**Re: Circle K – Eagle Ranch & Irving at 9610 Eagle Ranch Blvd NW  
Erosion and Sediment Control Plan  
Engineer's Stamp Date – 1/2/2024 (C13E028)**

Based upon the information provided in your submittal received 1/5/2024, the above referenced ESC Plan cannot be approved until the following comments have been addressed.

**EROSION CONTROL PLAN - INITIAL**

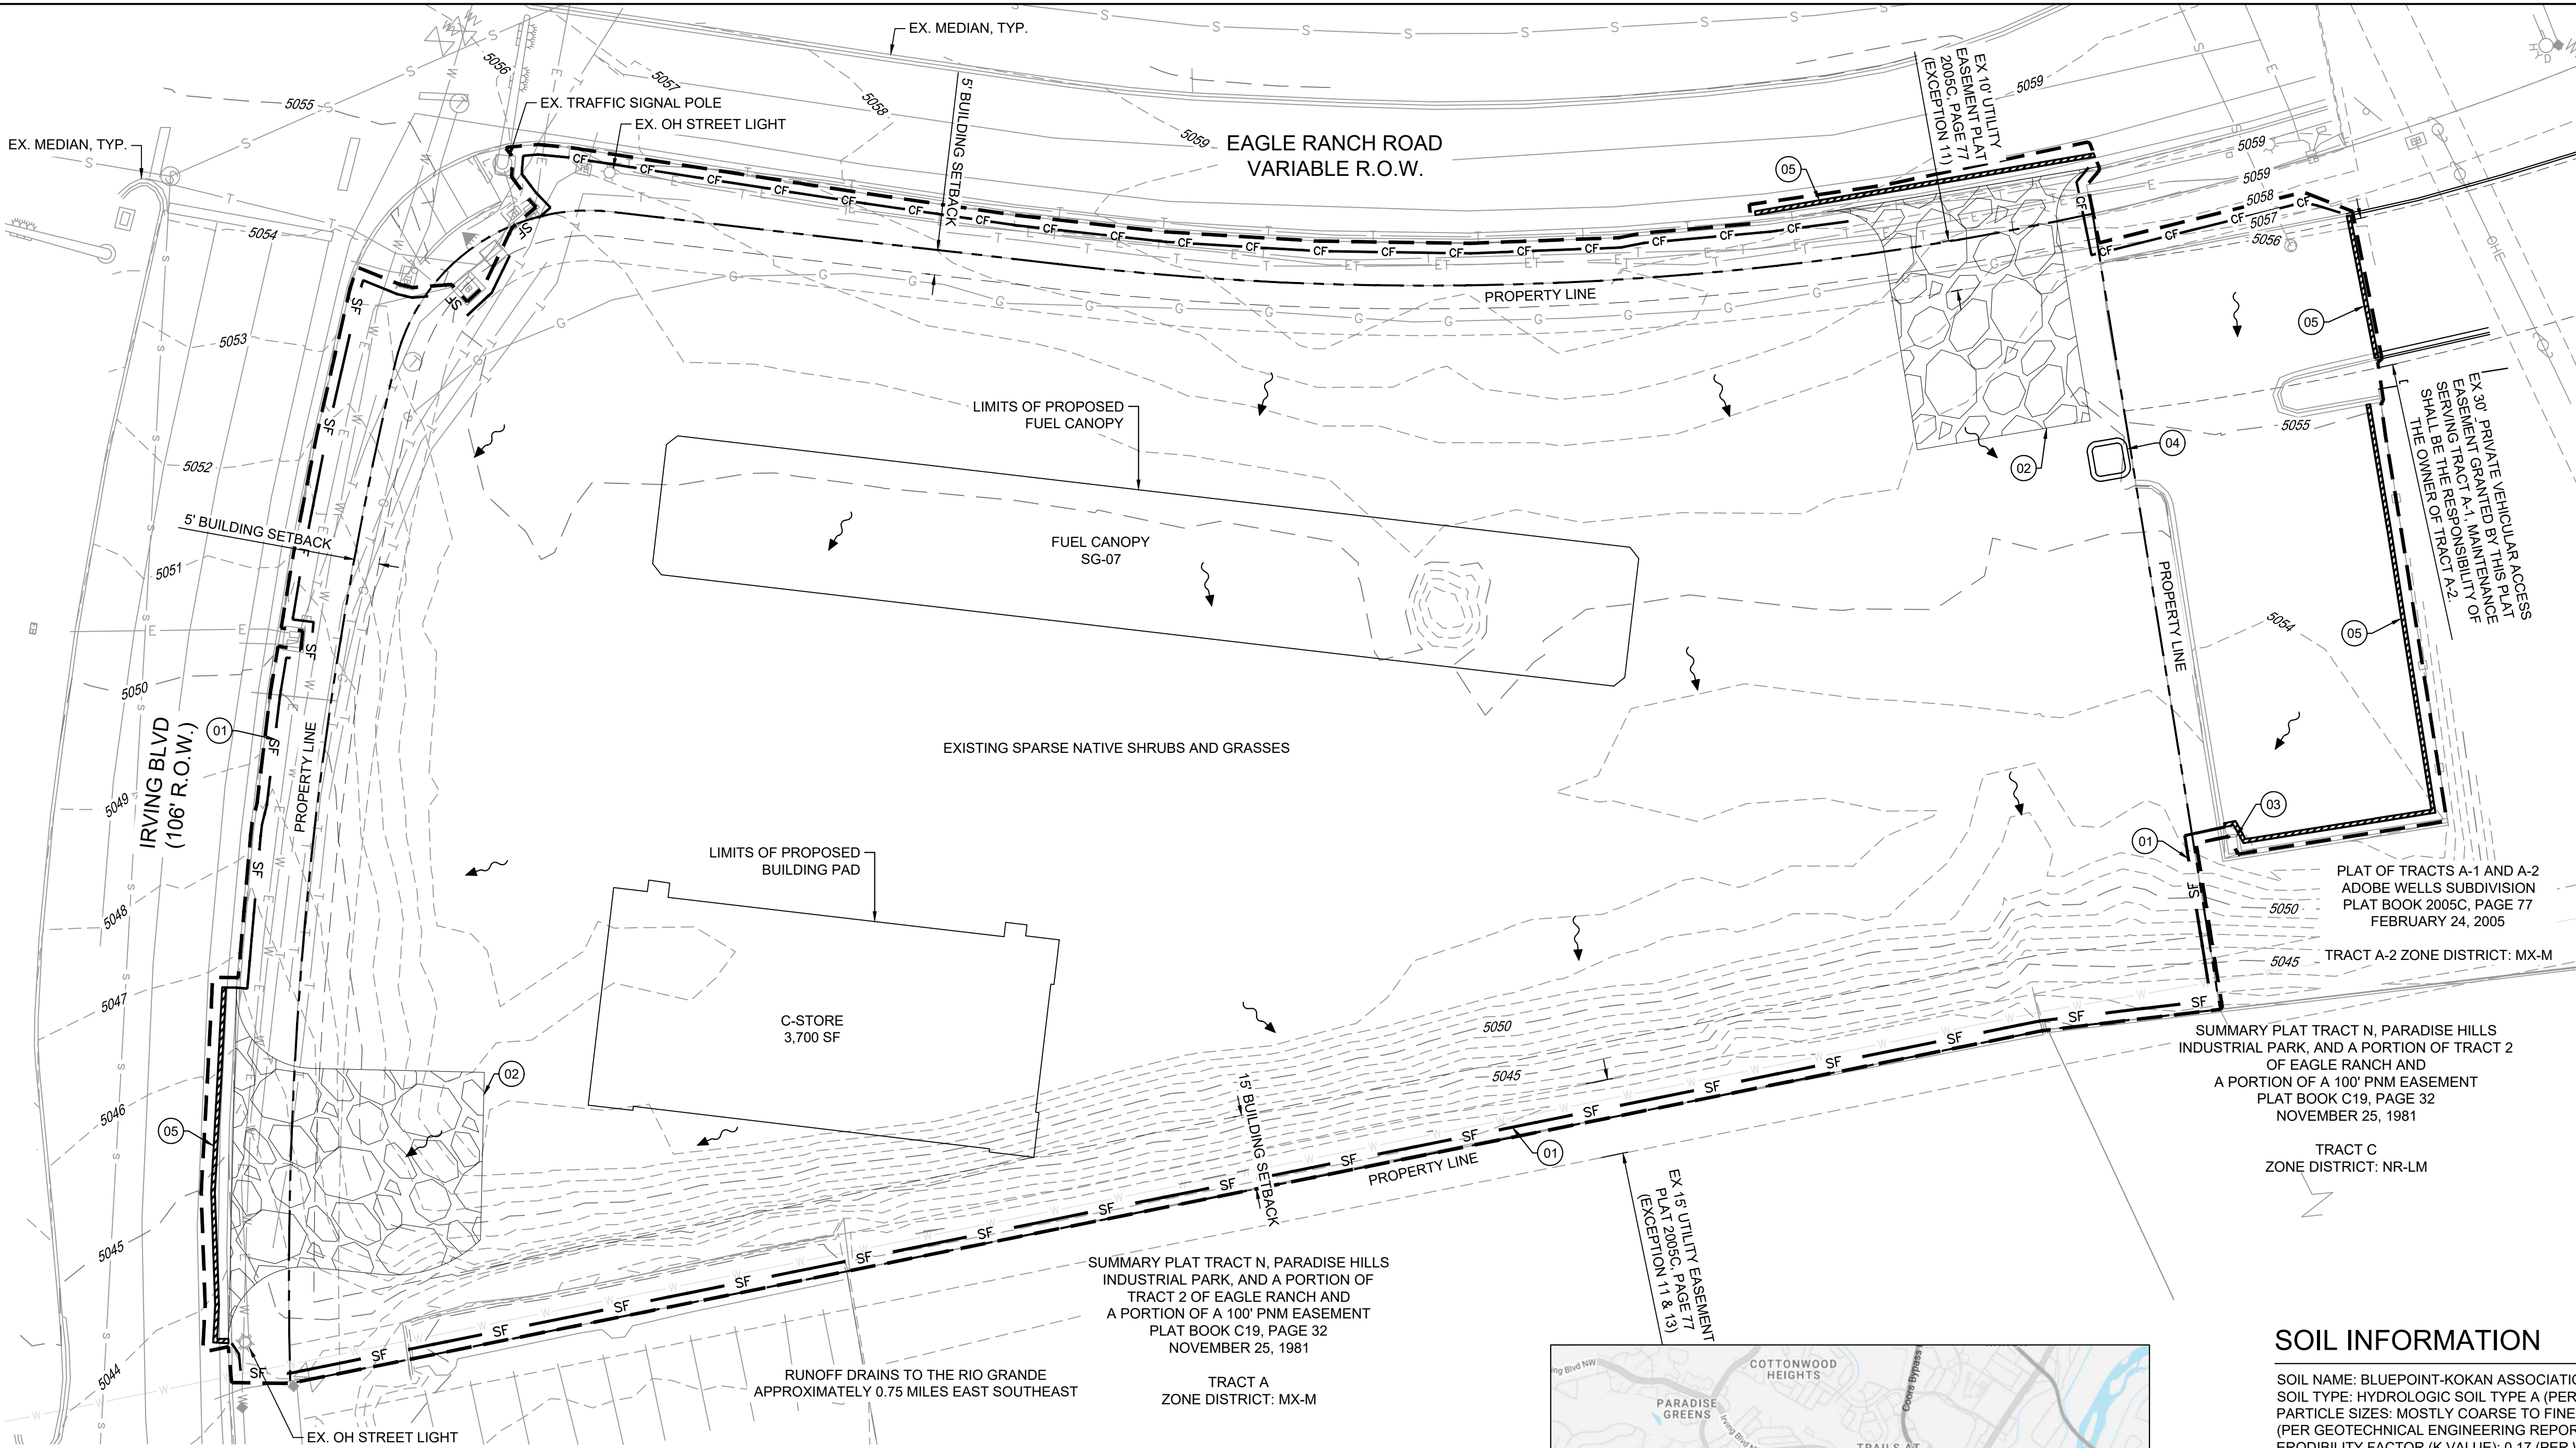
1. This plan shows a large gap in the silt fence at the low corner where you have located the southwest construction exit contrary to CGP 2.2.3 and contrary to standard Erosion and Sediment Control (ESC) practices. You must revise the design of your BMP controls to ensure that stormwater runoff is ponded before it leaves the site in accordance with CGP 2.2.3. At a minimum provide continuous silt fence across the low corner with no gaps. The construction exit located at the high corner of the site, the northeast corner, is acceptable.

Construction exit has been removed and continuous silt fence is now provided.
